## **Development Facilitation Team (DFT) – Review Comments**

**Project No: PR-2022-007875      Date: 06/28/2023      Agenda Item: #6 Zone Atlas Page: C-11**

**Legal Description: Lot 1 Block 5 Unit 26, Volcano Cliffs**

### **Application For: SD-2023-00113 – PRELIMINARY/FINAL PLAT**

FINAL PLAT
Lot 1-A, Block 5
Volcano Cliffs Unit 26

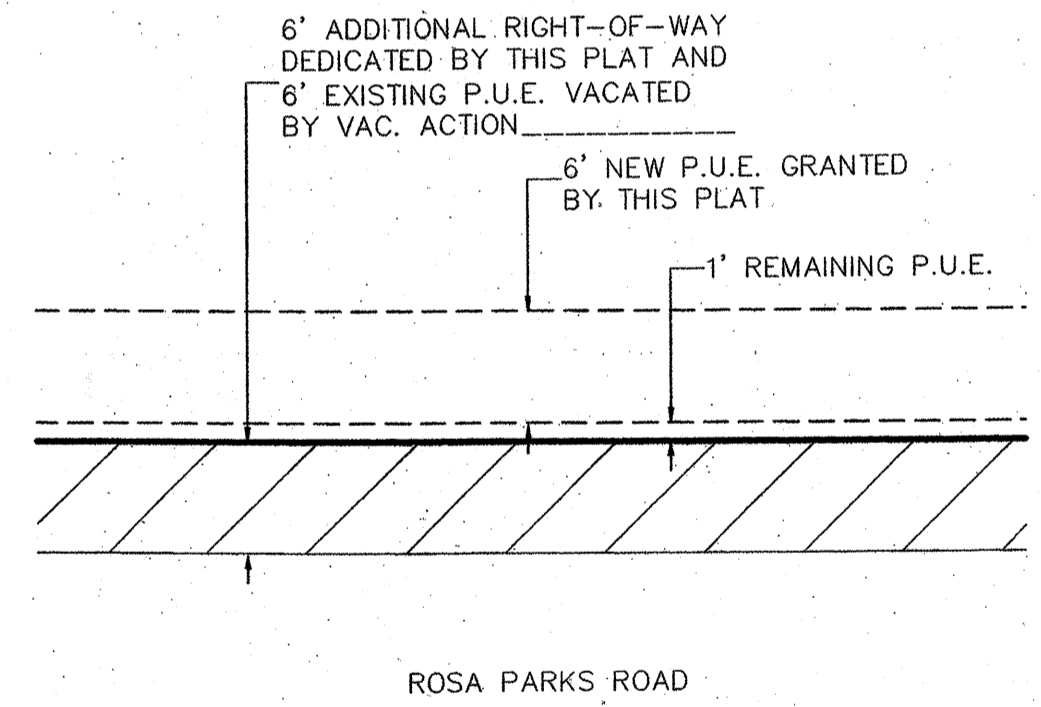
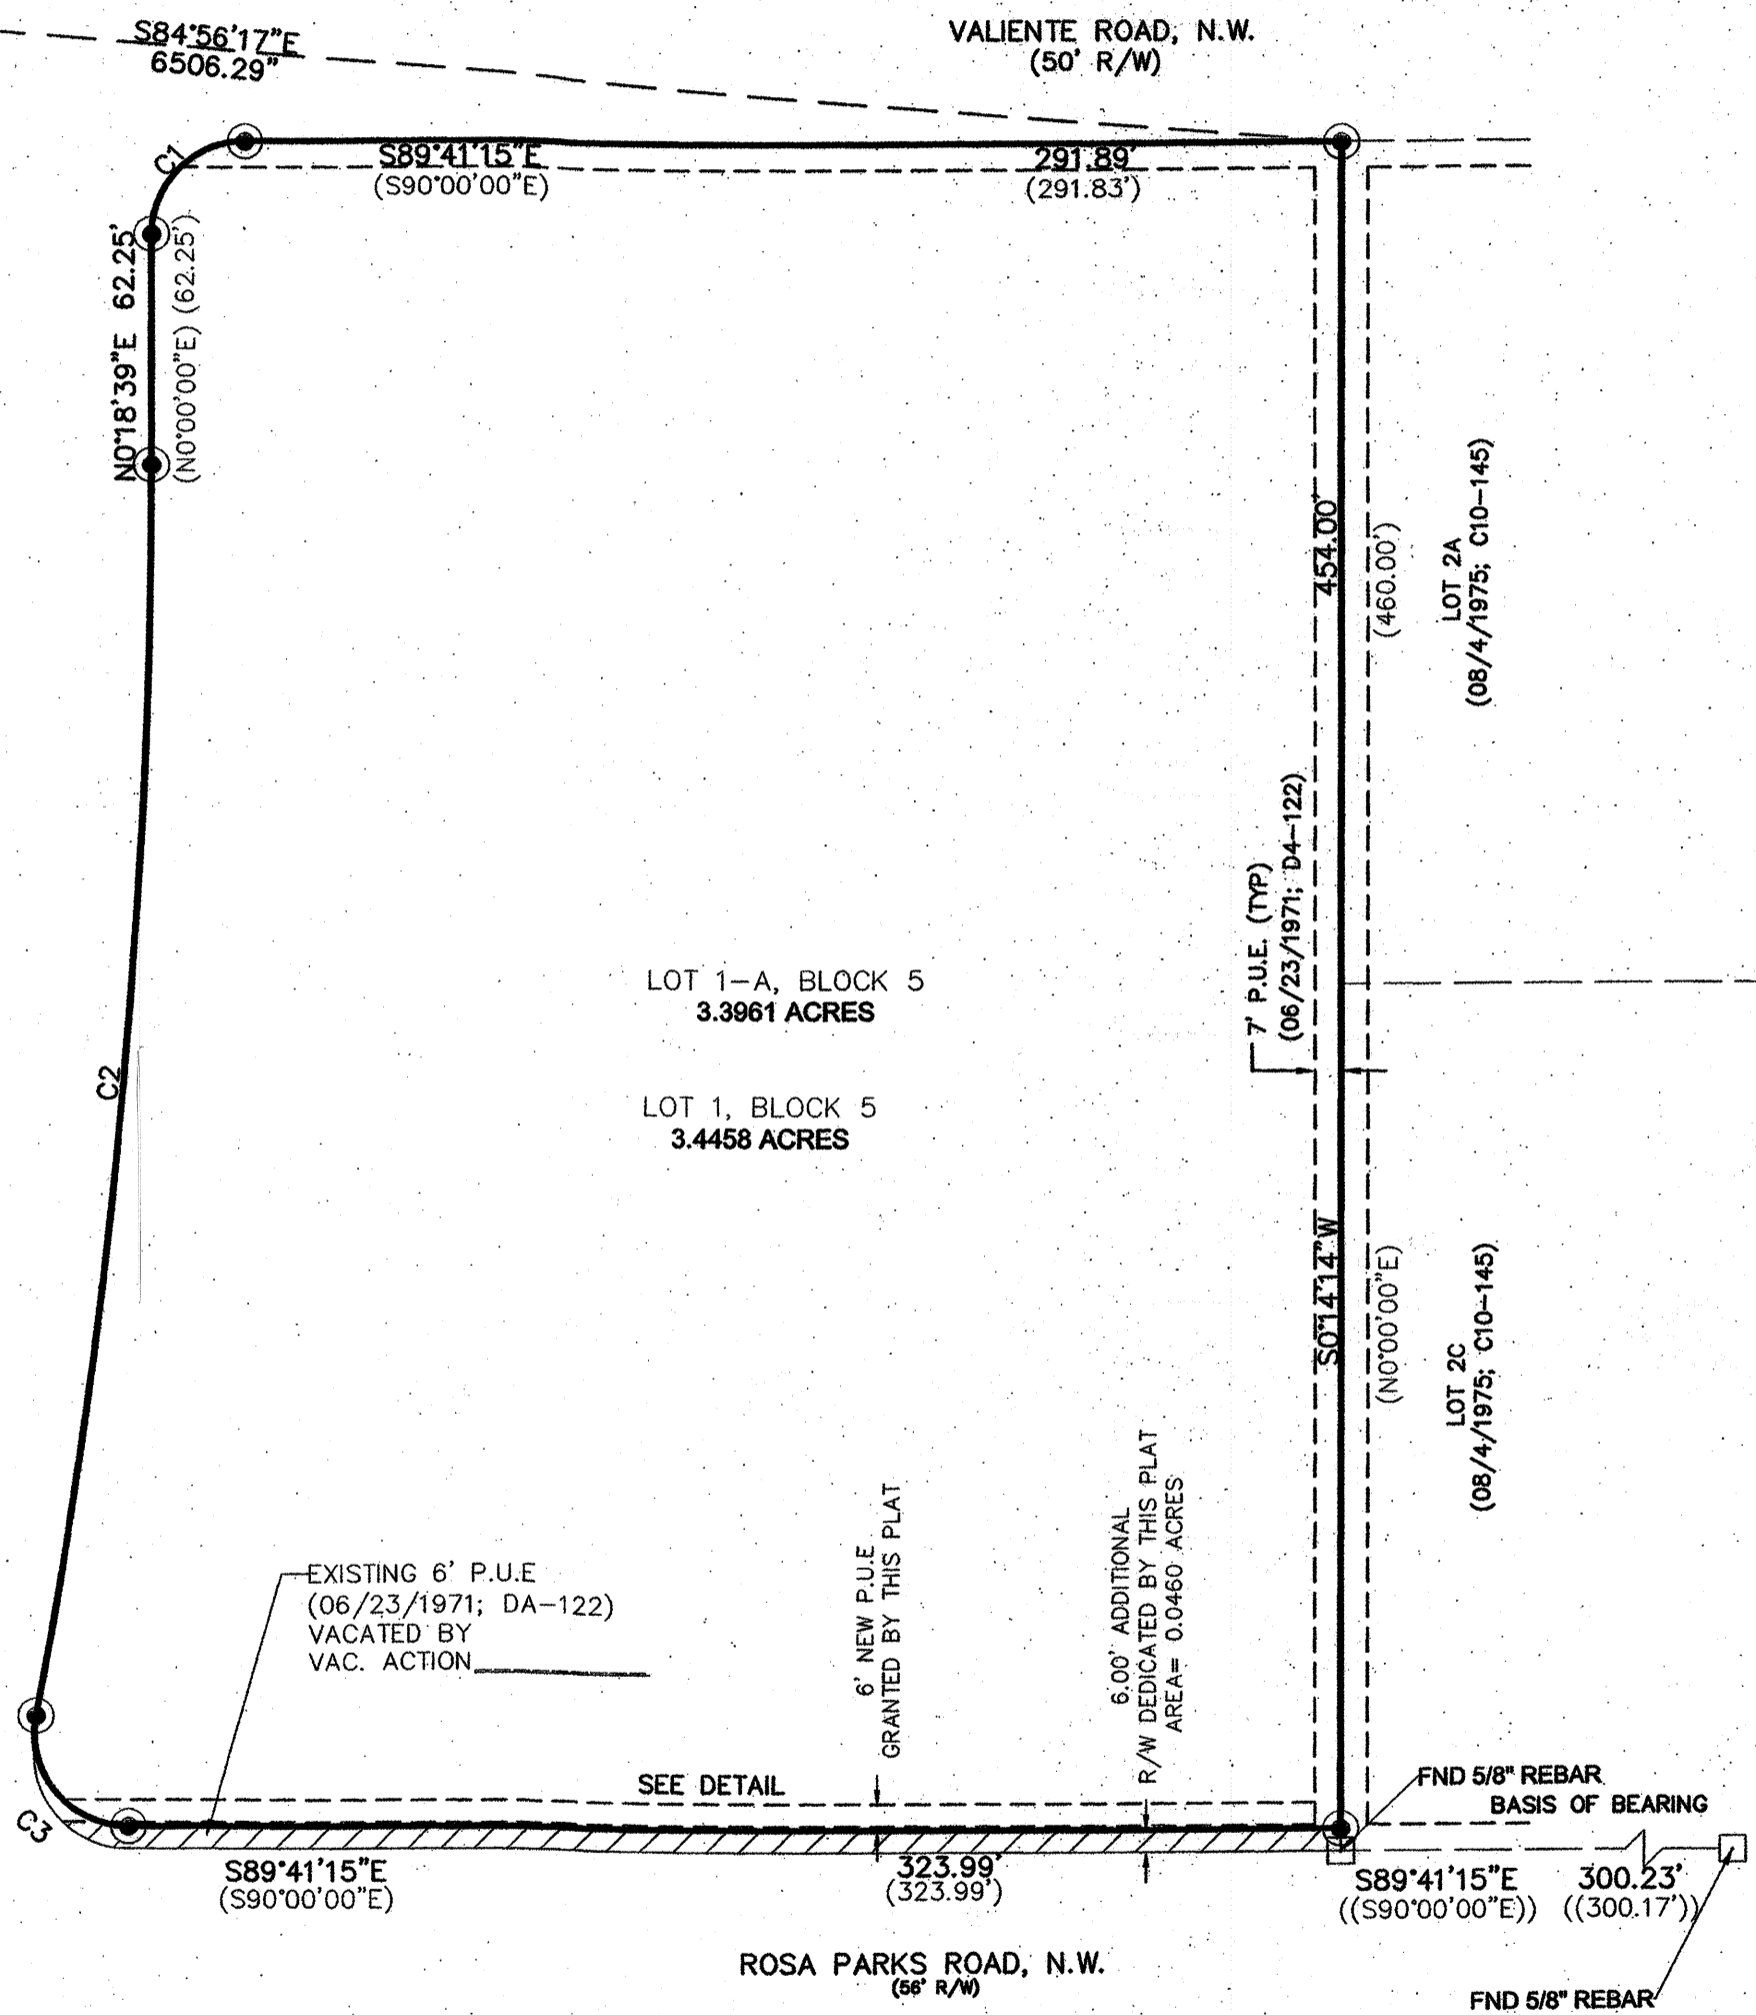
- The application number must be added to the Plat prior to final sign-off.
- The AGIS office must approve the DXF file and proof of approval must be provided prior to final sign-off of the Plat.
